Ribble Valley Borough Council
By email

Your ref 3/2026/0106
Our ref DC/26/578
Date 27-MAR-26

Location: Plane Tree Farm Chipping Road Chaigley BB7 3LT
Proposal: Prior notification for general purpose agricultural storage building 18.28m long, 15.24m wide, 8.83m

DRAWING TITLE:
SITE LOCATION PLAN

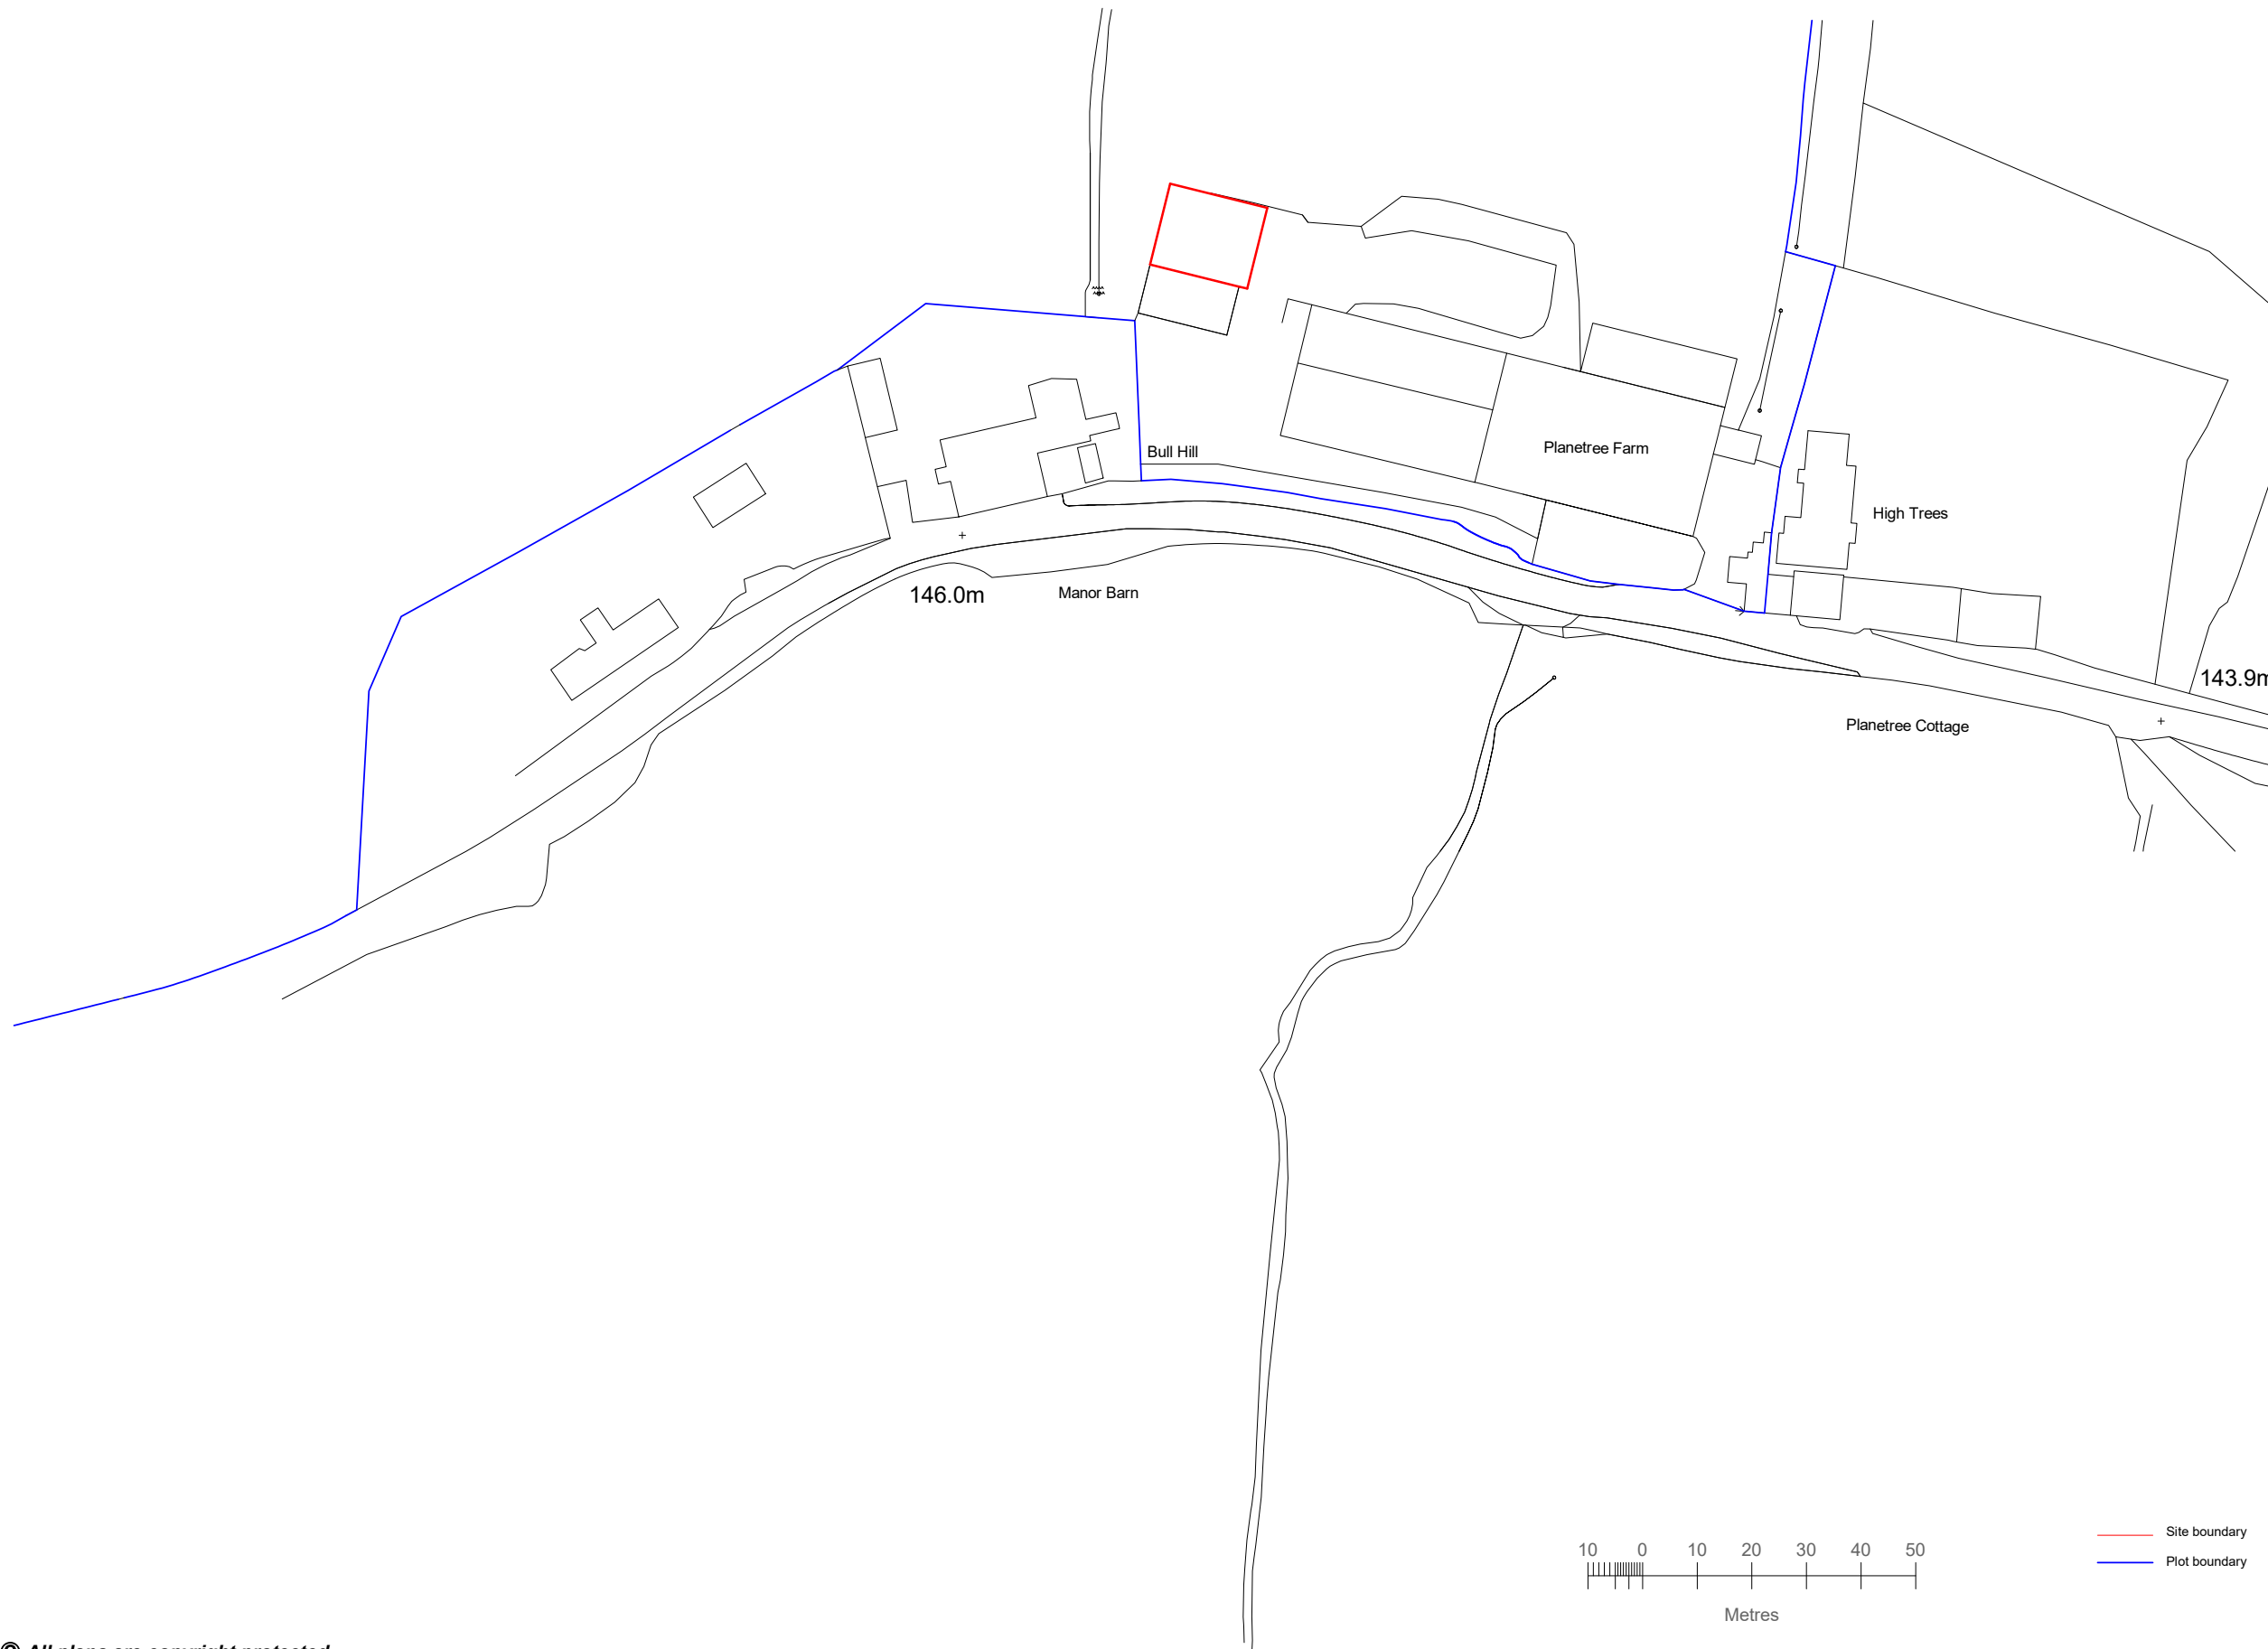
A large diameter trunk main is located in the vicinity of the site. It must not be built over, or our access to the pipeline compromised in any way. We require an access strip as detailed in our 'Standard Conditions for Works Adjacent to Pipelines', which can be found on our website: <https://www.unitedutilities.com/builders-developers/your-development/planning/building-over-or-working-near-our-assets/working-near-our-pipes/>. The applicant must comply with this document to ensure pipelines are adequately protected both during and after the construction period.

Whilst we note the application is a prior notification, following our review of the submission, we can confirm the proposal is not acceptable to United Utilities as proposed building is located in close proximity to the large diameter trunk main and its associated legal easement. It is appreciated that the process for prior notification may not consider building in close proximity to the water main, however there is a risk that as the scheme progresses, the applicant, or any subsequent developer, may discover that their plans are not implementable in their existing form, resulting in the applicant having to re-submit a new planning application.

No construction shall commence until details of the means of ensuring the water main that is laid within the site boundary is protected from damage as a result of the development have been submitted to and approved by the Local Planning Authority in writing. The details shall outline the potential impacts on the water main from construction activities and the impacts post completion of the development on the water main infrastructure that crosses the site and identify mitigation measures to protect and prevent any damage to the water main both during construction and post completion of the development. Any mitigation measures shall be implemented in full in accordance with the approved details.
